Application No: P/9/21/HH
Site Address: 9 Kings Drive Pagham PO21 4PY
Description of works: Single storey rear extension with flat roof together with alterations to existing bay windows to the front of the property.

Thank you for your internet representation made on 11th March 2021 which has been recorded as an objection with the comments as follows:

dwg.title As Built Elevations @ A3

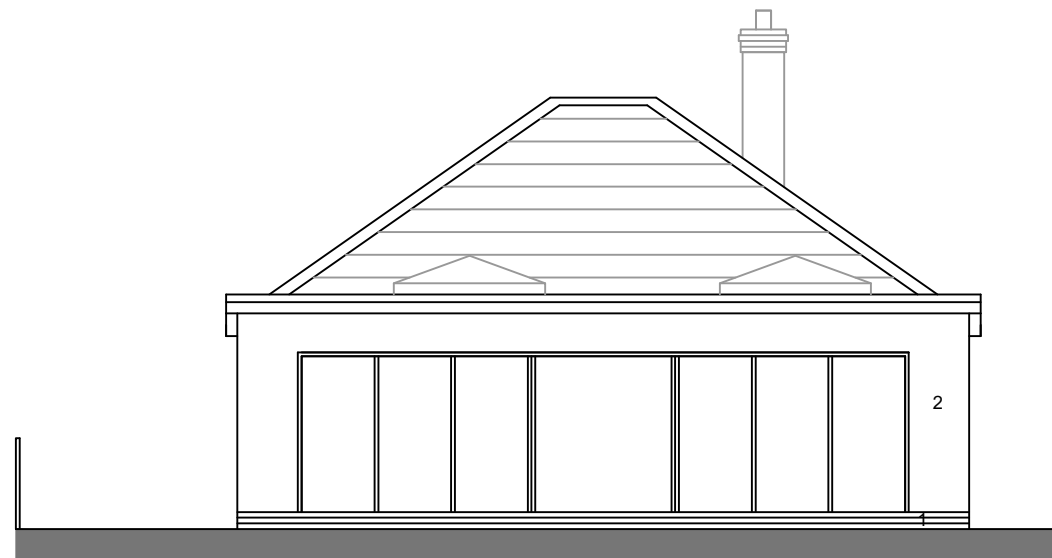
Firstly the removal of the bays at the front of the house, put it odds with all the surrounding bungalows and detracts from the period character and charm that this collection of bungalows, both sides of the street, enjoy along Kings Drive. The result is a flat faced, generic box facade, that is not sympathetic to existing properties.

The rear extension has also been built to such a height and length, that is the dominant view as you walk along Kings Drive and does, in no way come close or even attempt to tie in /blend with the existing bungalows. There is also no flow between the old bungalow and new extension. The eaves of the extension are a good two feet higher than the eaves of the old bungalow, making the extension appear larger overall, than compared to the proportions of the original property. Also, the extensions height, has meant it has been cut into the existing bungalows roof structure and totally change the old shape of the bungalows roof. What was once symmetry and pleasing to the eye, is now an odd shaped bungalow roof, with a huge one and a quarter story dominant box, pushed into it at the rear.
